OXFORDSHIRE COUNTY COUNCIL'S RESPONSE TO CONSULTATION ON THE FOLLOWING DEVELOPMENT PROPOSAL

Application no: 22/02025/REM

Proposal: Reserved Matters to 16/02586/OUT - Access, layout, scale, appearance and landscaping details for Phase 1B for up to 12 No knowledge economy units in Use Class E (former Use Class B) (14,972 sq m gross external area) with associated parking, landscaping, utilities and access

Response Date: 3rd November 2022

DRAWING NUMBER: **226701_PD02** REVISION: .

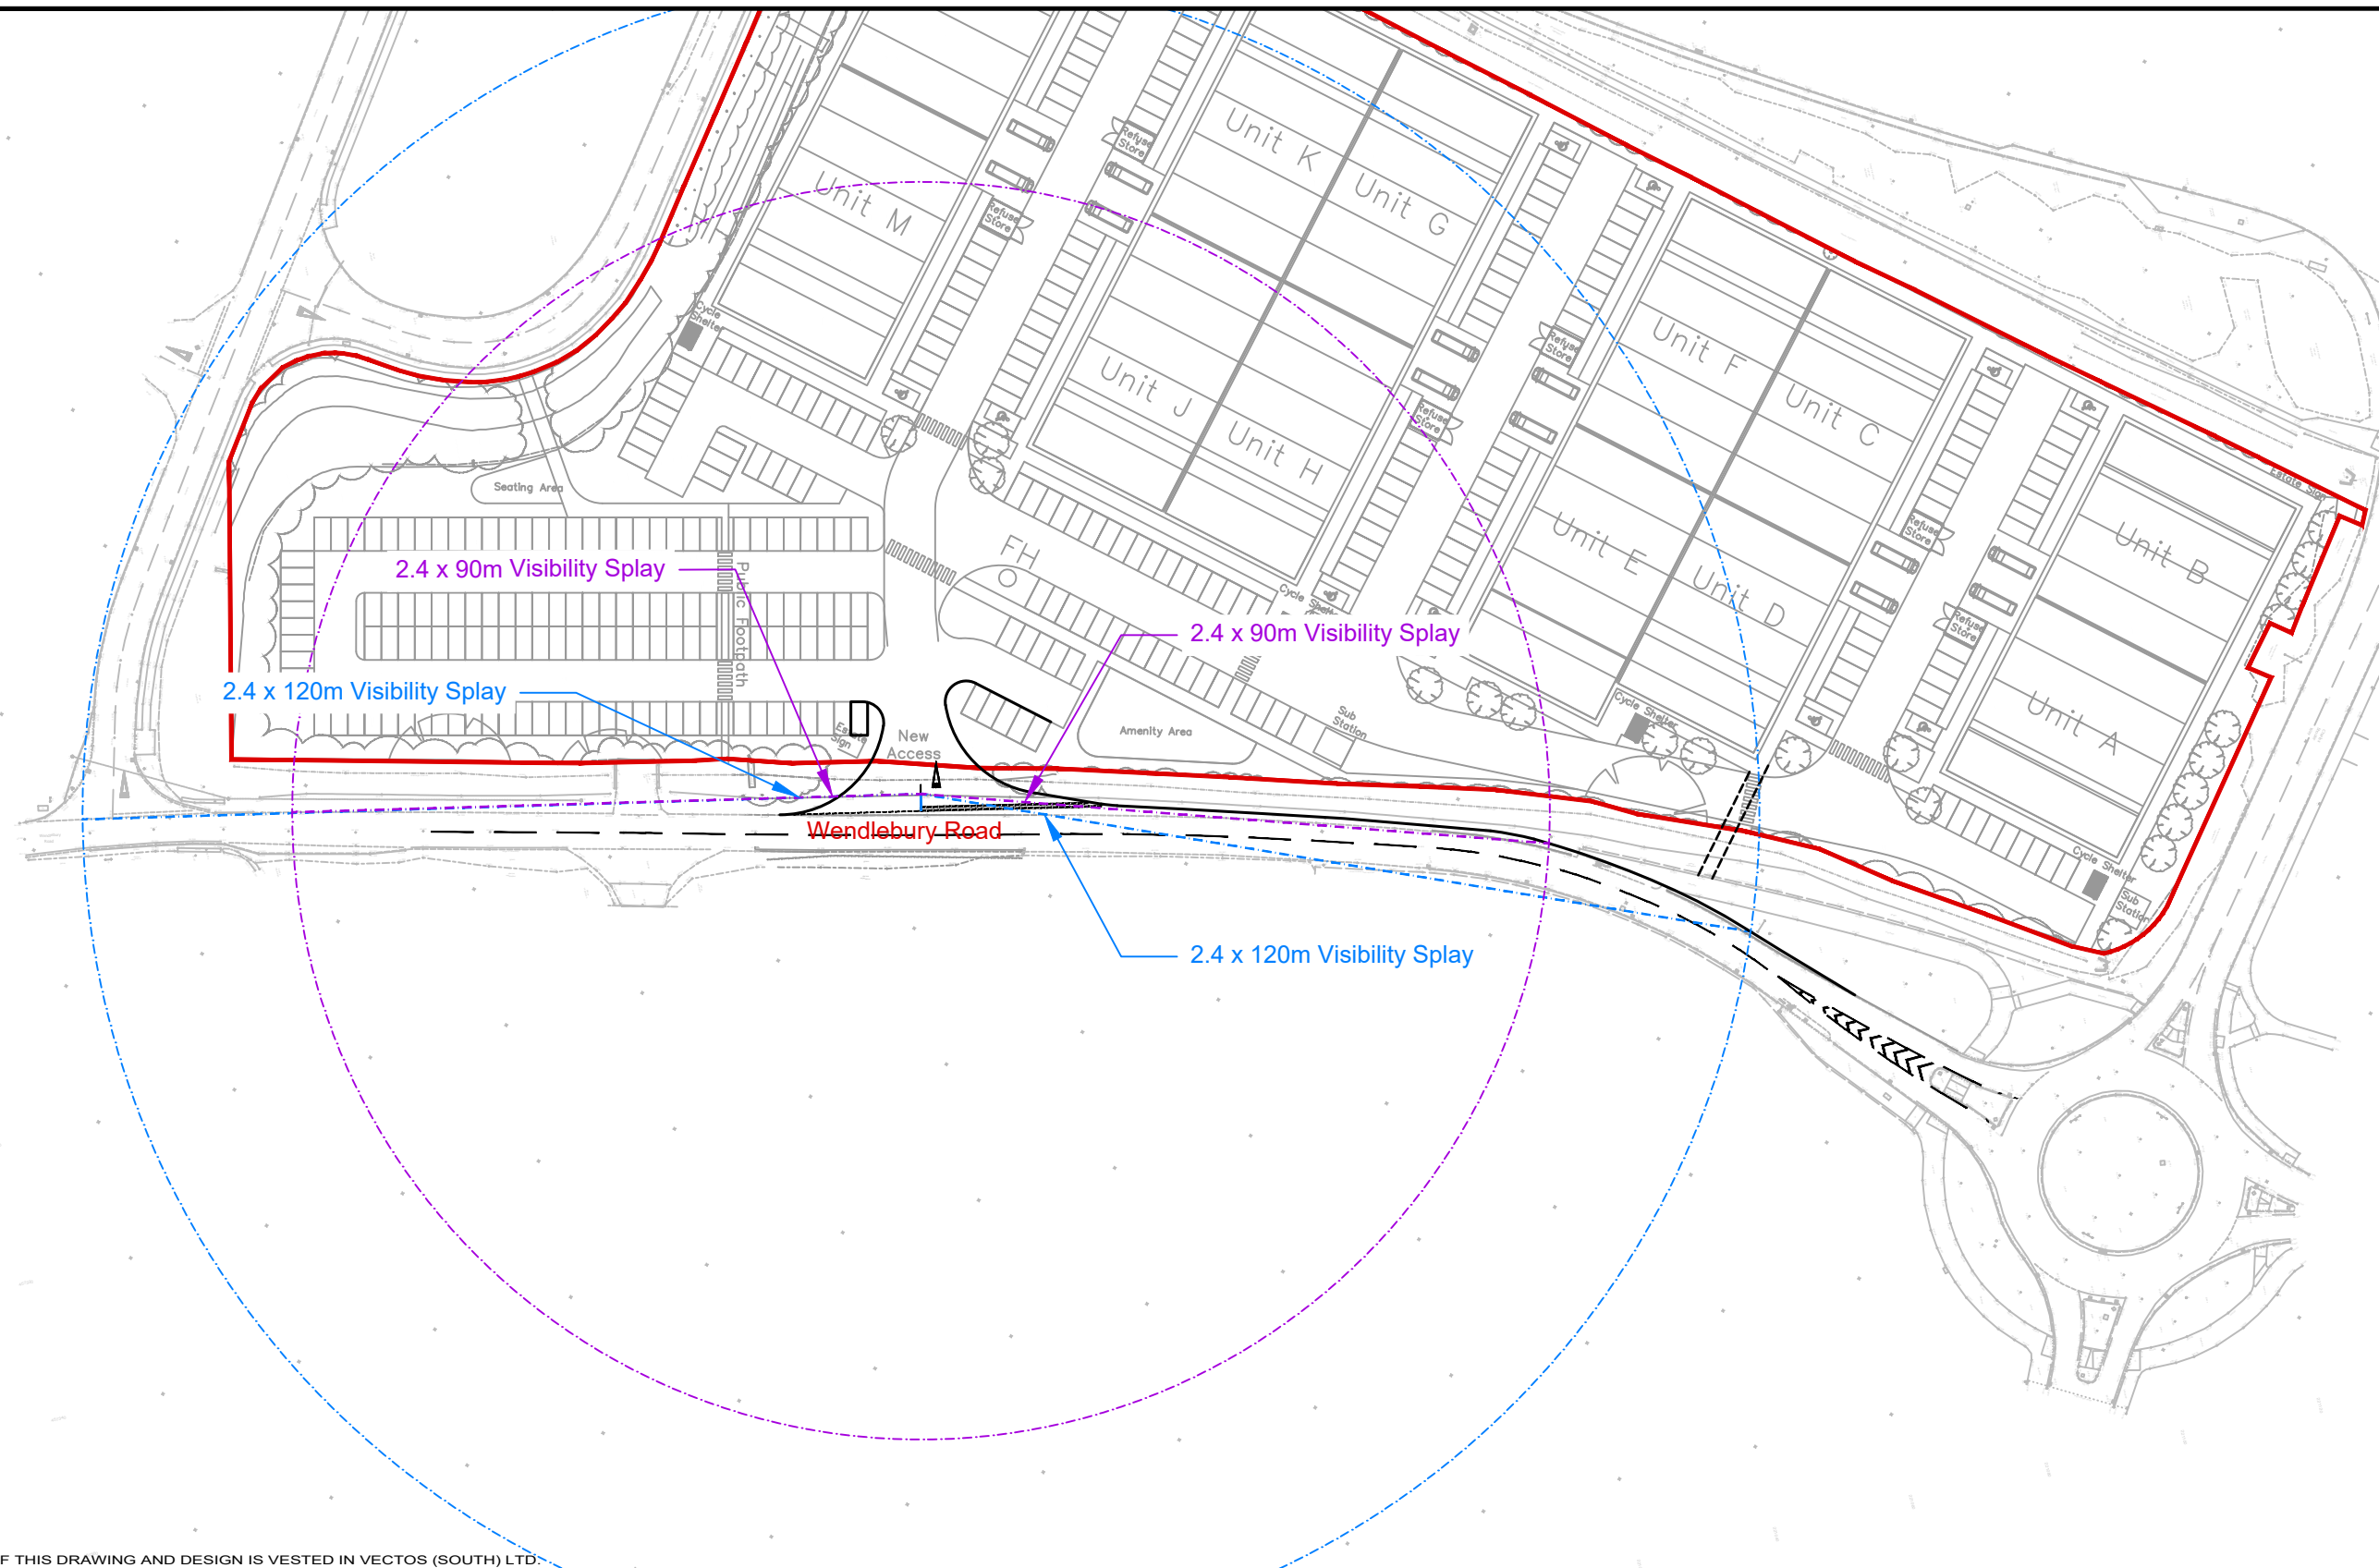
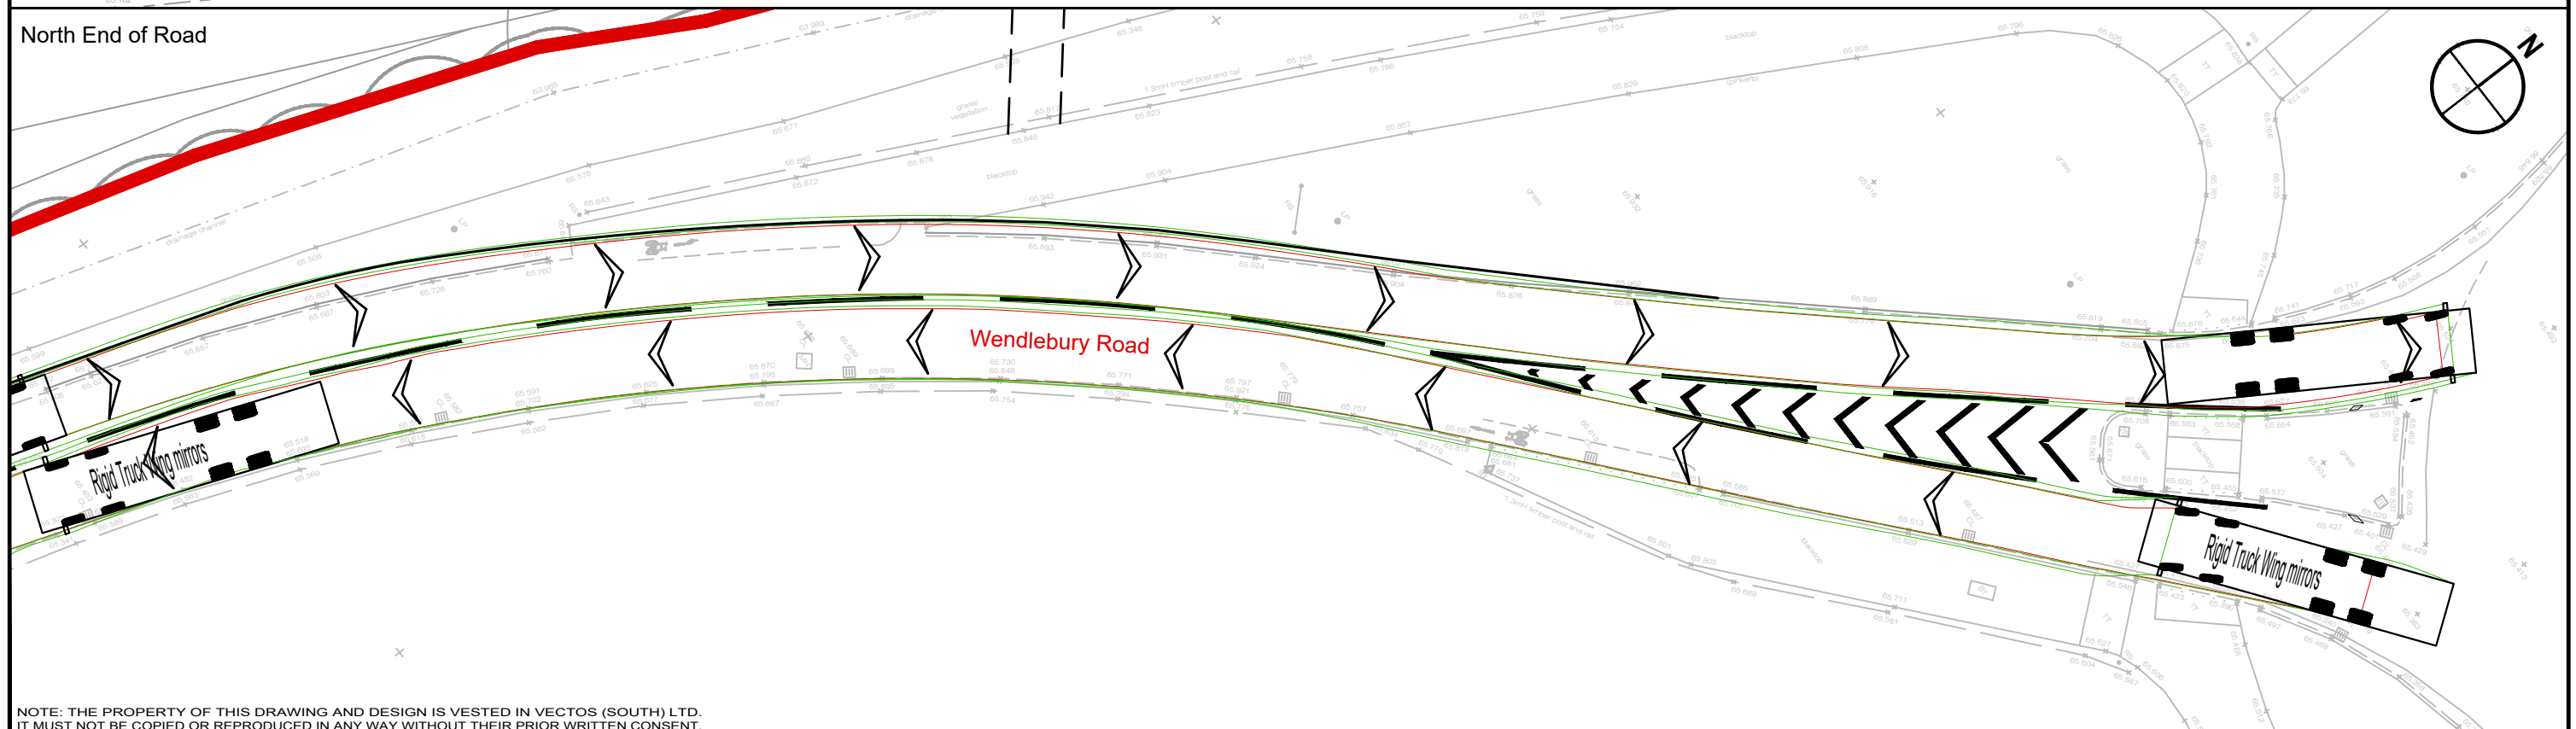
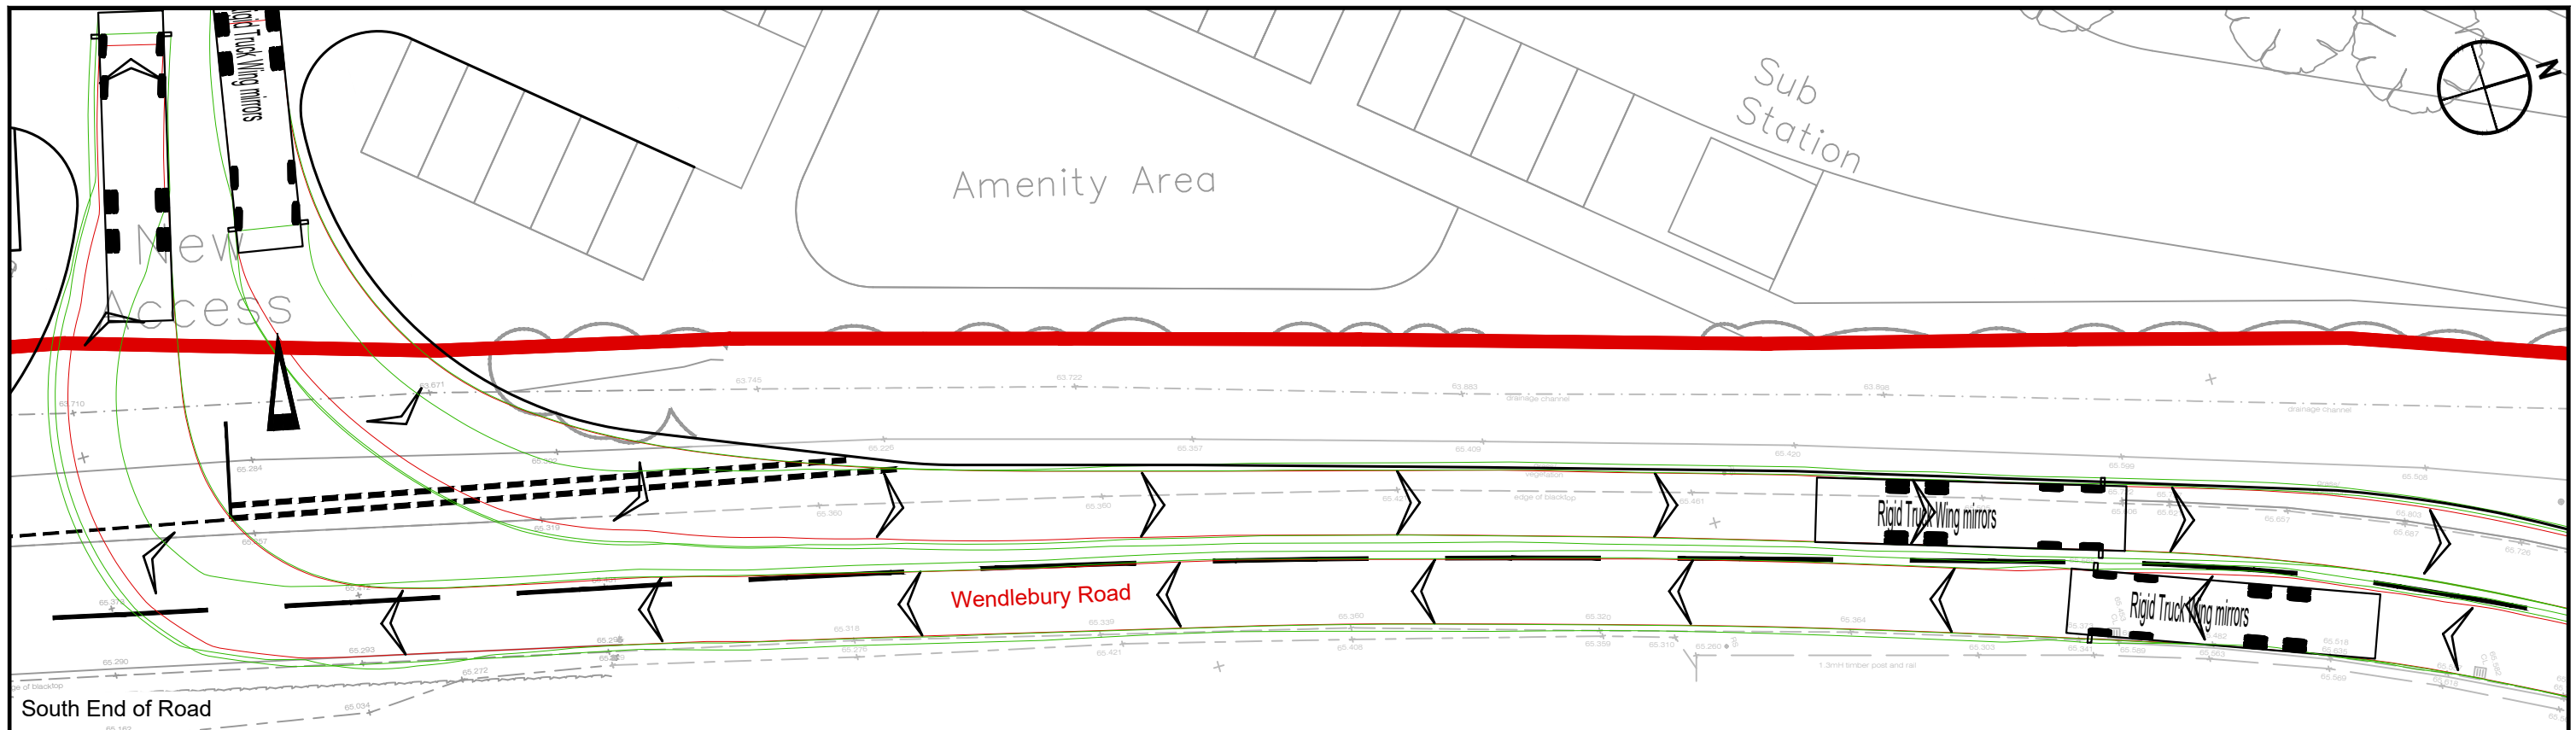
Long Section and Vertical Alignment

The County has reviewed the long sections and vertical alignments at the access and they are acceptable. This is no longer a reason for objection.
